Response to Submissions

4 Murray Rose Avenue

Commercial Development

Submitted to NSW Department of Planning and Environment
On Behalf of GPT RE Limited

## The Ledge

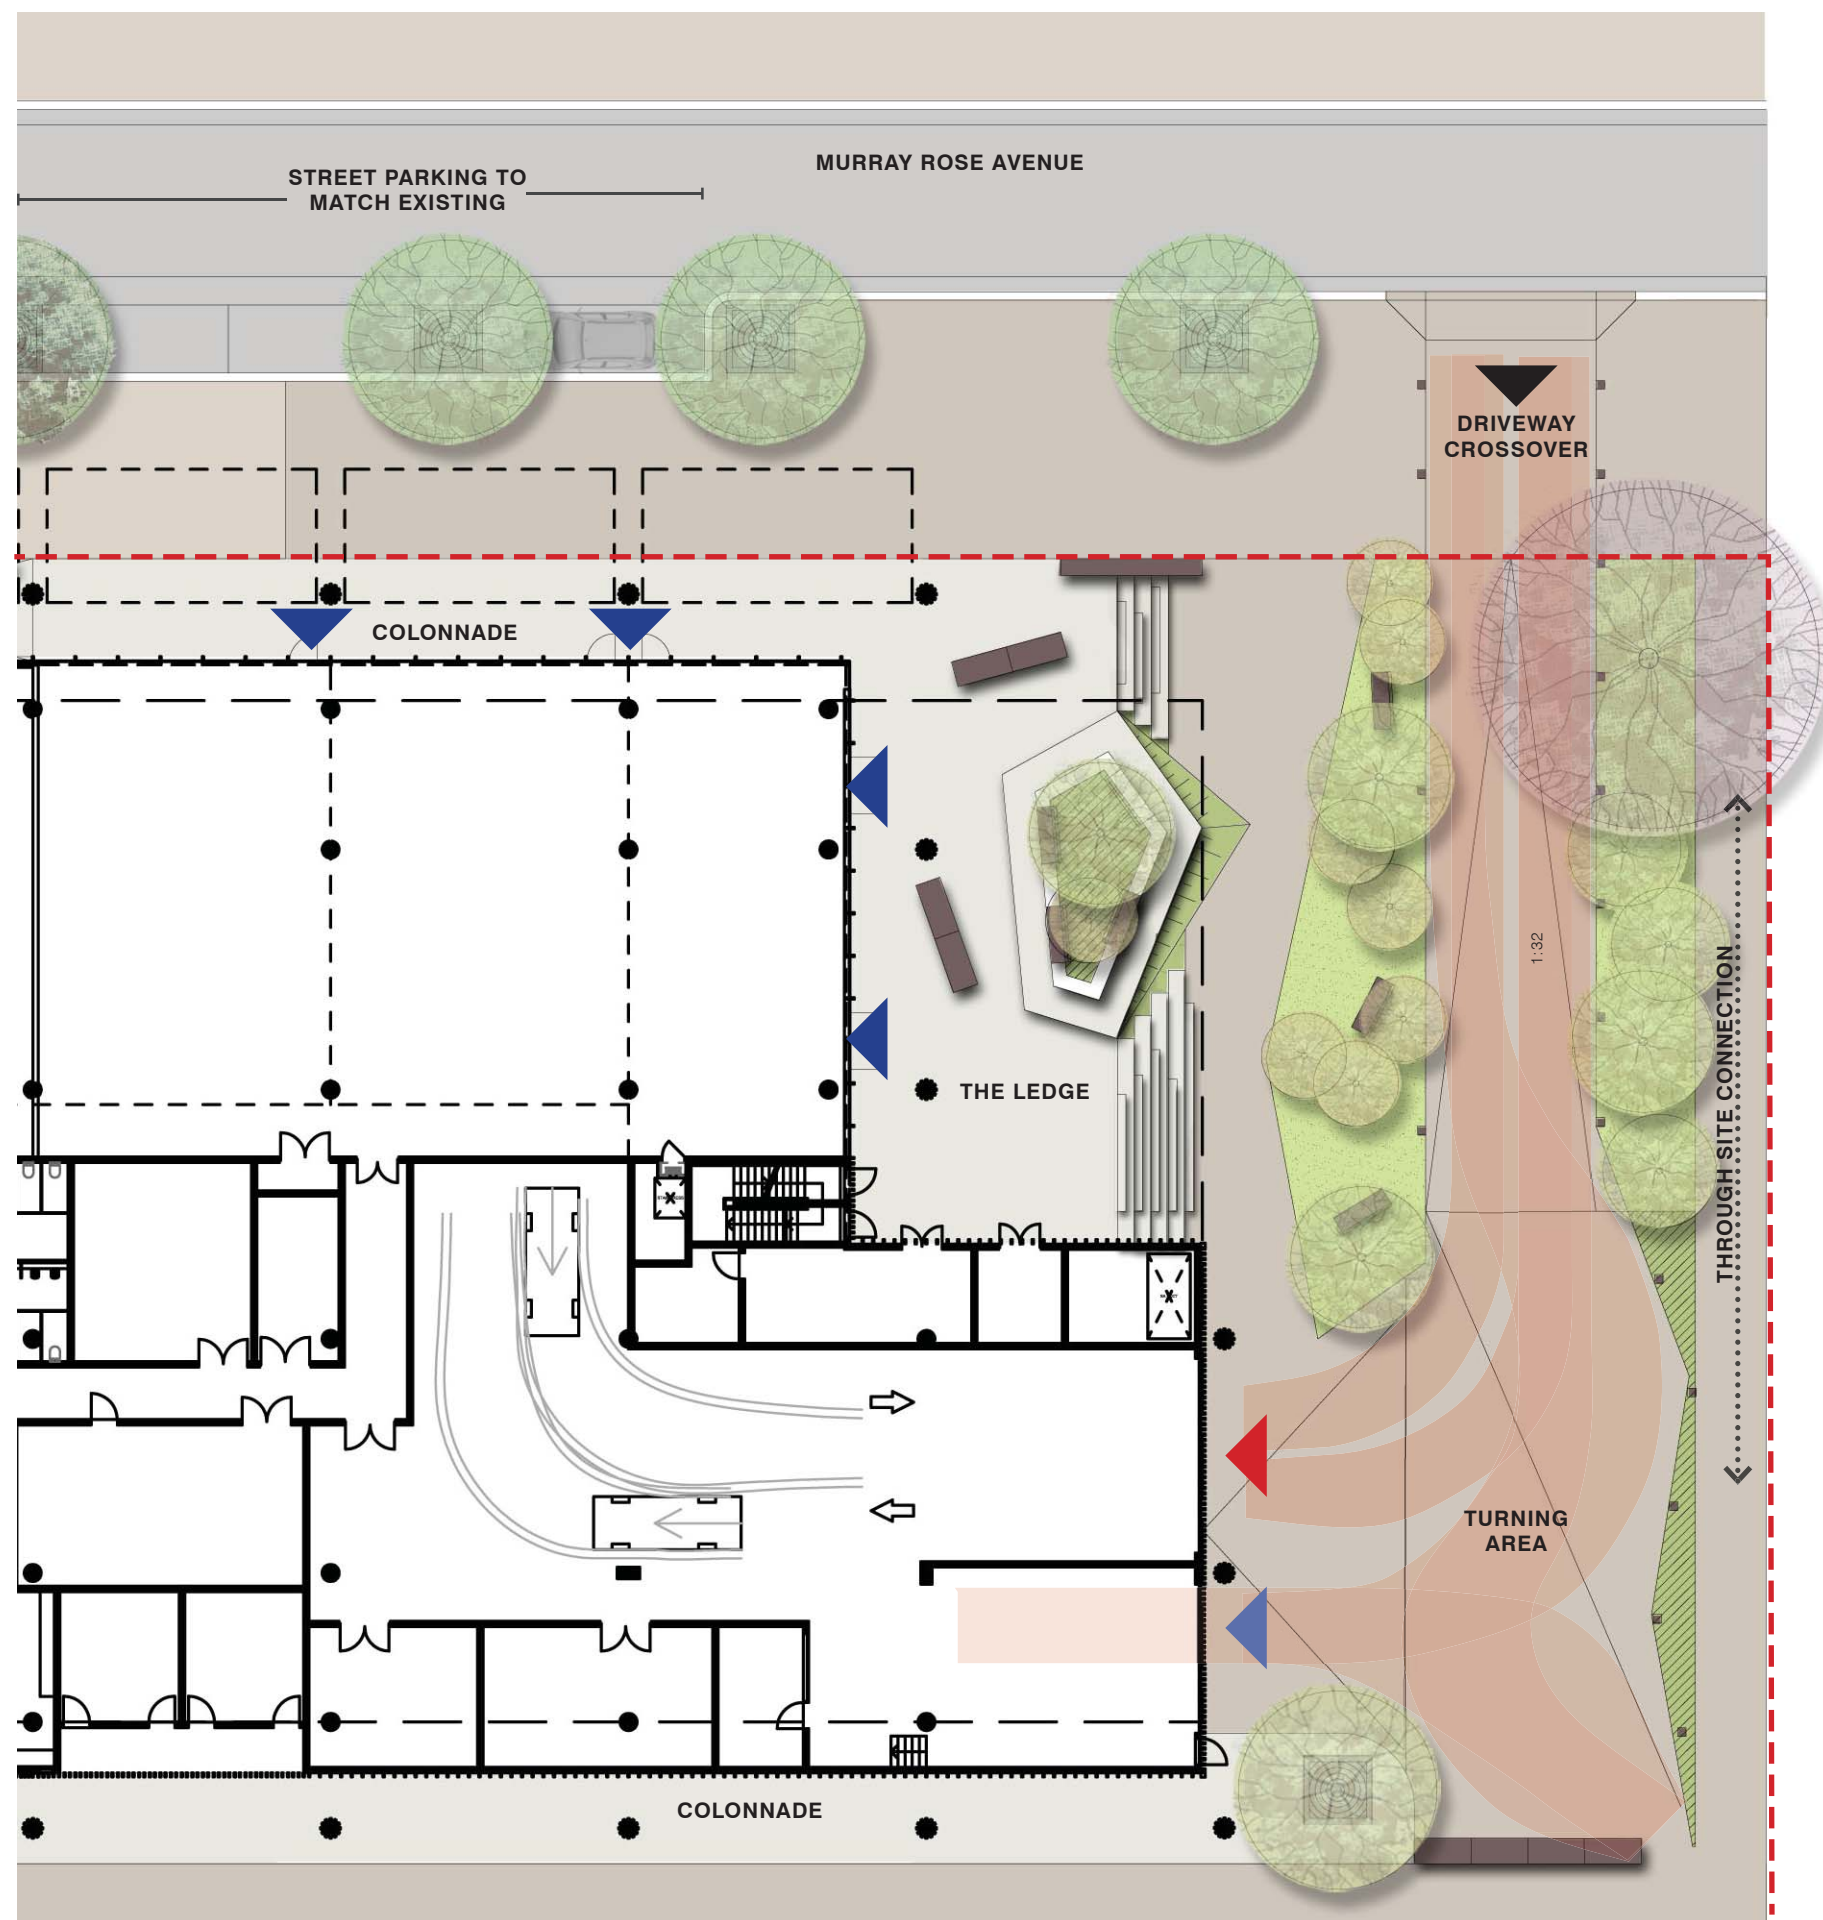
Landscaping & Trees	
<p>1. 'The Ledge' has trees located over podium/edge of basement with a limited amount of bench and 'bleacher' seating. The external seating should meet the SOPA Access Guidelines and provide backrest and side support. Trees must be provided with adequate 'rootable soil volume' and an automatic irrigation system.</p>	<p>The Landscaping Plans (Appendix B) have been amended to illustrate that the seating will meet the SOPA Access Guidelines and include backrest/ side supports. In addition, all trees on the podium will be provided with adequate rootable soil volume and an automatic irrigation system will be specified for all planting on the podium.</p>
<p>2. The proponent will need to provide details of the pot sizes or detailed species information is provided for proposed planting.</p>	<p>Noted. A condition of consent is sought in this regard</p>
Paddock Park	
<p>1. The new location of Pocket Park is compromised by the location of 3 exhaust air flues; this is not supported and the structures should be integrated into other parts of the building away from public areas as it will adversely impact on the amenity of this public space and the health/ amenity of workers and residents.</p>	<p>The Architectural Drawings at Appendix A, illustrate the relocation and integration of the car park ventilation system within the building fabric.</p>

## Paddock Park Future

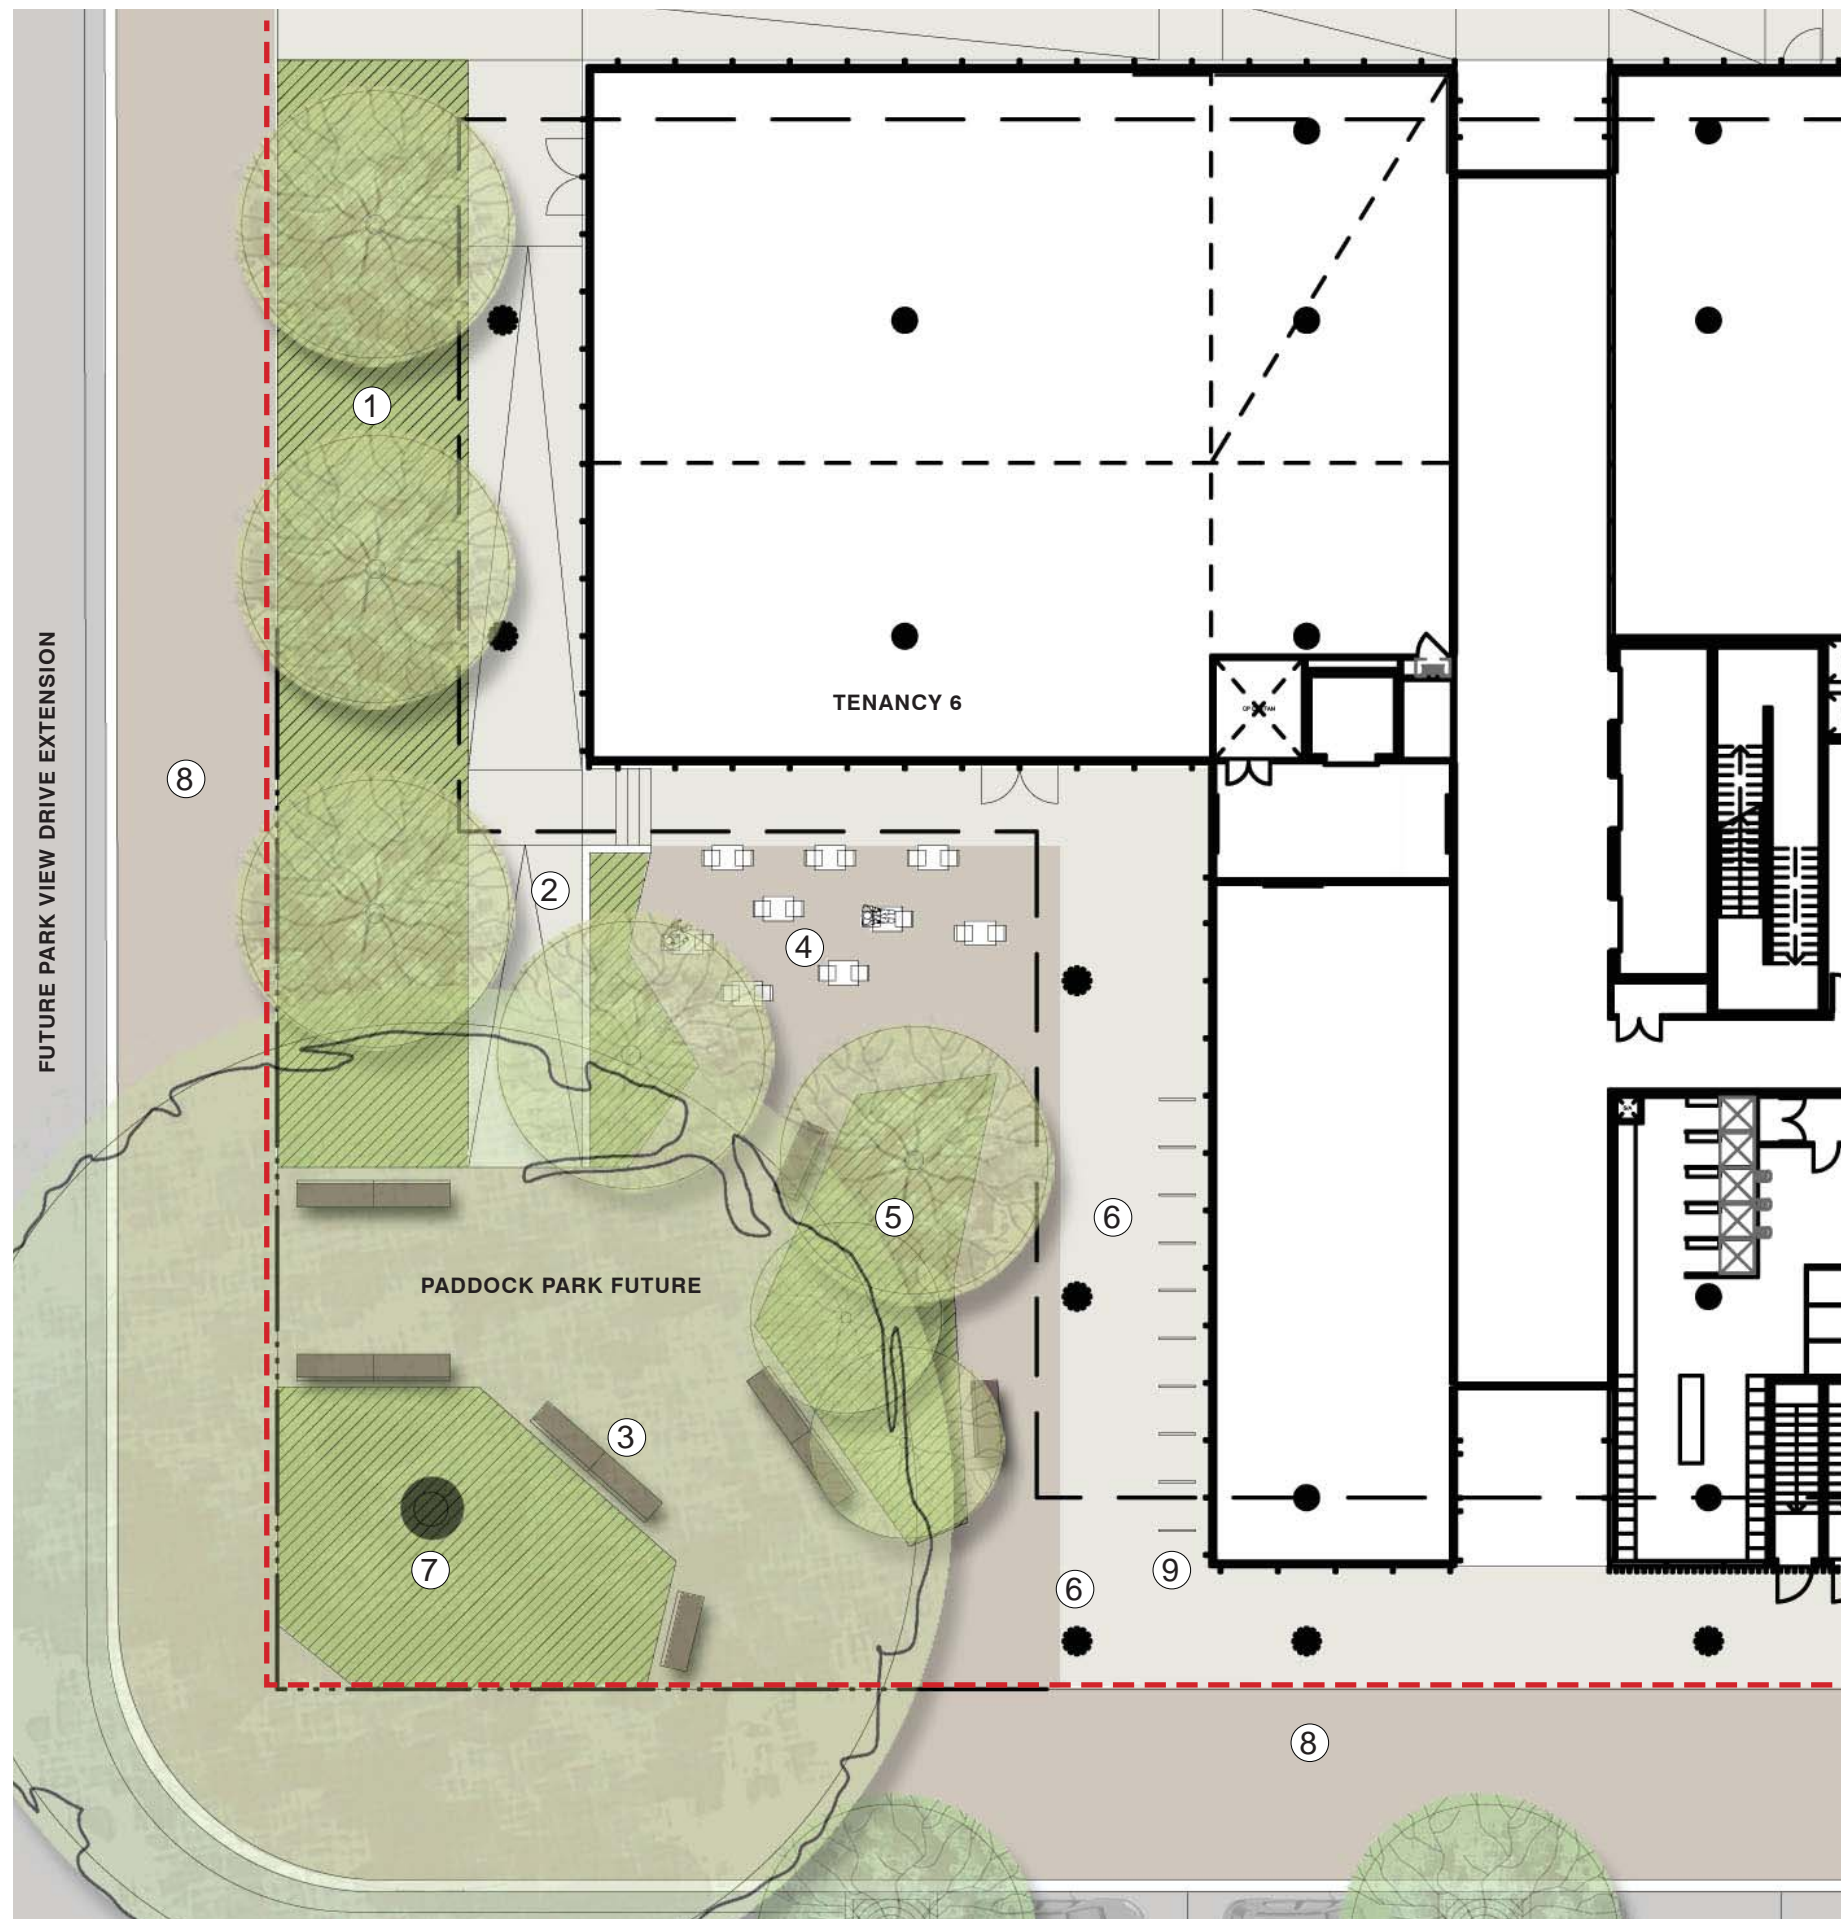
2.	The 'Shared Zone' and 'Turning Area' has major safety issues; namely vehicle conflicts with pedestrian and cycle movement across the mouth of the vehicle ingress/egress to the basement car park and loading dock. It is recommended that the pedestrian/cycle shareway be located on the eastern perimeter to avoid conflicts with vehicle movements.	The amended design includes a dedicated pedestrian zone on the eastern part of the site (adjacent to the future No.2 Murray Rose Avenue development site). Please refer to the amended Landscape Plans at Appendix B .

<p>3. Pocket Park is more likely to evolve as a pocket urban space rather than a grassed area. Turf is not a suitable surface treatment as this area will be overshadowed for much of the day. The area also has extensive ramping which will need to be DDA compliant.</p> <ul style="list-style-type: none"> – Ideally this pocket space could be further activated by complimentary ground floor tenancies such as food & beverage uses, as this area will be a major pedestrian linkage point connecting pedestrian movement between QUAD 4, Brick Pit Park and P6 car park. 	<p>Refer to comments above and amended Landscape Plans at Appendix B. SOPA and GPT are satisfied that no further design amendment is required.</p>

1 South Elevation, Future Dawn Fraser Avenue
1:200

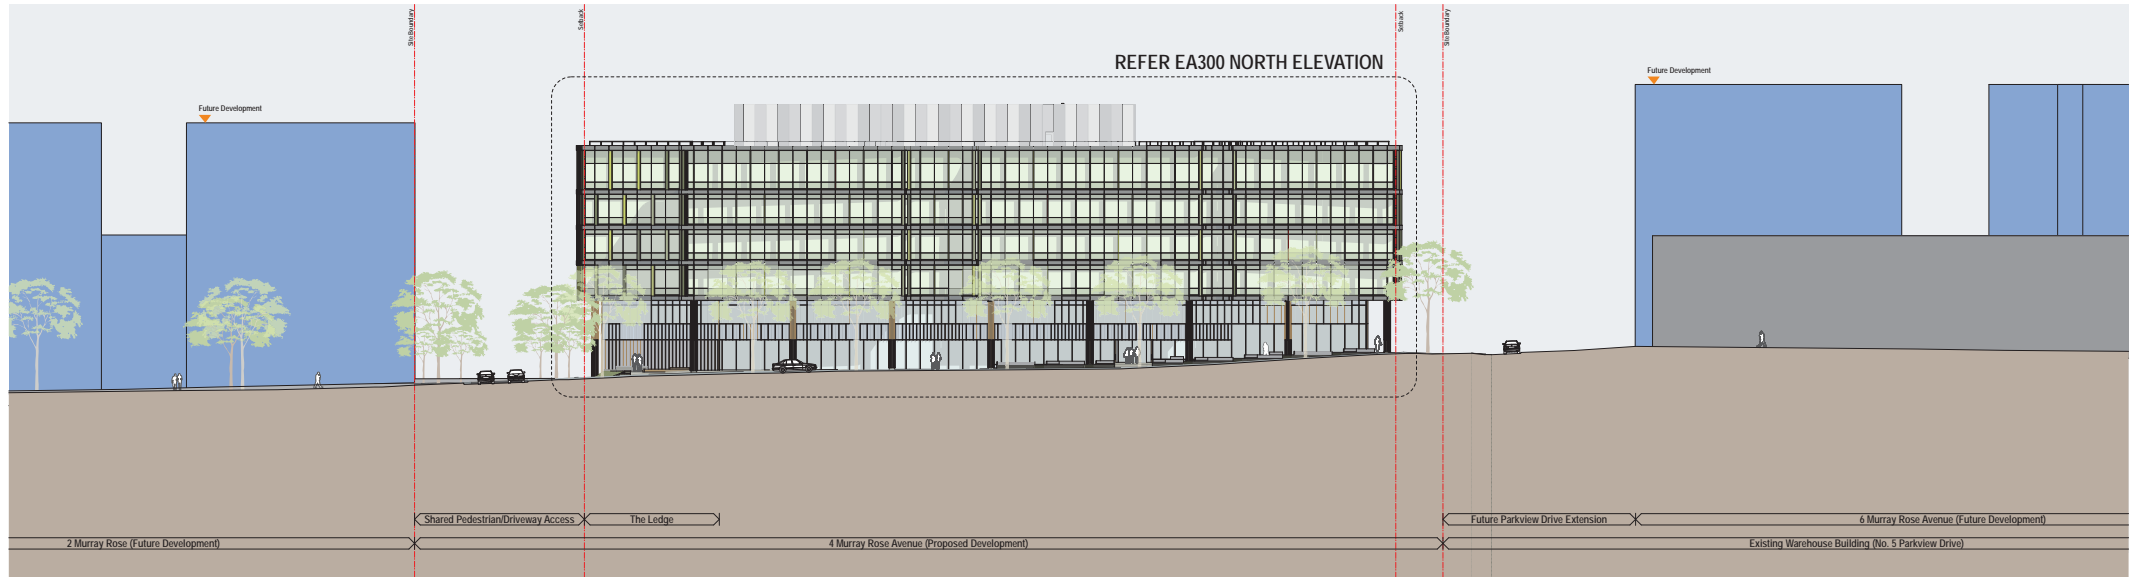
3.	The colonnade width should be increased 4m clear between the glazing line and the inside of the columns (SOP Master Plan 2030 – are 4.3). Columns should be redesigned to not impede the pathway.	Colonnades have been designed to improve public amenity and improve the interface with building entry points and street edge activities. Murray Rose Avenue and Dawn Fraser Avenue frontages are provided with a covered pedestrian pathway of more than 4m. The Murray Rose Avenue frontage is further enhanced by the introduction of the future awnings to the public domain. The localised introduction of columns, 10m apart, provides a minimal impediment and has been designed to ensure that compliance with accessibility standards can be achieved. SOPA and GPT RE Limited are satisfied that no further design amendments are required.

4.	The double height colonnades will need to provide low louvres/secondary shading to adequately protect pedestrians and outdoor diners from the elements.	In response to SOPA comments the design has been amended to include the placement of a future awning structure(s). This approach allows flexibility and an integrated approach for inclusion when the functionality of street level uses compliments occupation of the public domain (café and restaurant fitouts). Refer to the amended Architectural Drawings (Appendix A). SOPA and GPT RE Limited are satisfied that no further design amendment is required.

5.	Sun shading and other façade articulation should not extend more than 300mm outside the building envelope (Master Plan 2030 – Part 4.6.7).	The building design, in particular the articulation of the facades is enhanced by the varying building depth. Whilst some of the elements of the façade articulation exceed 300mm it is our view that the reason for the control is to promote privacy, provide a transition between the public and private area and reinforce the street hierarchy and layout. It is considered that the building design achieves these objectives and meets the intent of Part 4.6.7 of the Masterplan without causing any adverse impact. Following further discussion, SOPA and GPT RE Limited are satisfied that no design amendment is required in this respect.

ISSUE	RESPONSE
<p>6. Service spaces (change rooms, garbage, switch room, sub-station etc.) facing the future Dawn Fraser Avenue frontage; a significant future street, are not supported. Retail uses are required on this frontage (MP 2030 Fig 4.1). Some of these service functions should be relocated to the basement. At least 50% of the Dawn Fraser Avenue frontage will need to have active retail uses.</p>	<p>The building has been designed to maximise street level activation, and to minimise and integrate services within the building footprint. This includes:</p> <ul style="list-style-type: none"> - A through site foyer activating both Dawn Fraser and Murray Rose. - An additional pedestrian entry from 'The Paddock Park'. - Retail activation to public domain spaces including 'The Ledge' and 'Paddock Park'. - Bike storage placed at street level to improve and encourage alternate means of transport to and from work. - Provide change rooms at street level with natural light to improve amenity. - Covered pedestrian access to all street and public domain building edges. - Vehicle and service access removed from major street frontages. - Where services are required they are grouped together to avoid breaking up street level activated frontages and have been designed to a high level material and finish integrated to the overall building design. <p>Furthermore the amended design:</p> <ul style="list-style-type: none"> - has removed the carpark ventilation system from the public domain; and - included a future awning that will provide flexibility for a variety of street level activities. <p>The key objectives demonstrate that a reasonable and considered approach to street level activation has been achieved. Refer to the amended Architectural Drawings (Appendix A). SOPA and GPT RE Limited are satisfied that no further design amendment is required.</p>
